HTE# BAPS2210-0006

EXISTING SEPTIC SYSTEM INSPECTION

PURPOSE OF INSPECTION: 14x28 Inground Pool

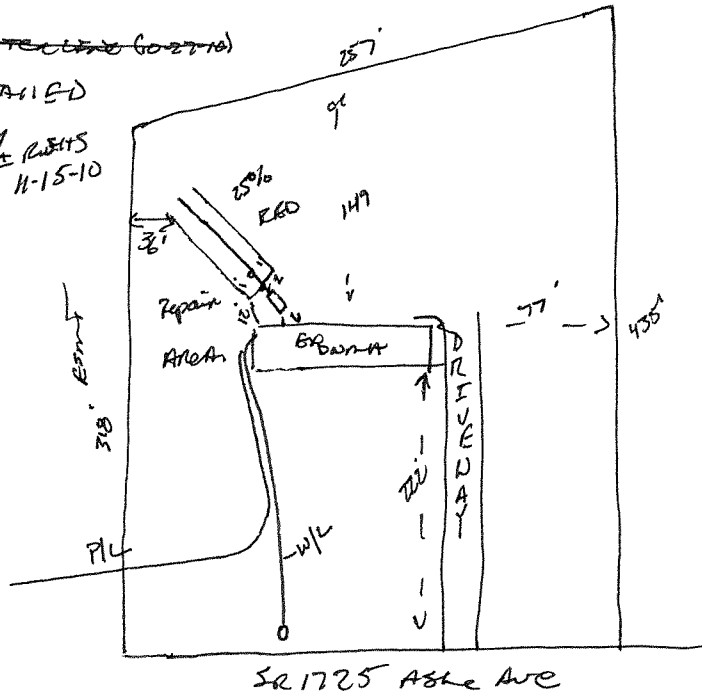
Advised to move Pool Away from DRAIN LINE 18" more Inches

**BUILDING MUST BE 5' FROM ANY PART OF SEPTIC SYSTEM
DO NOT DRIVE OR PARK ON SEPTIC SYSTEM**
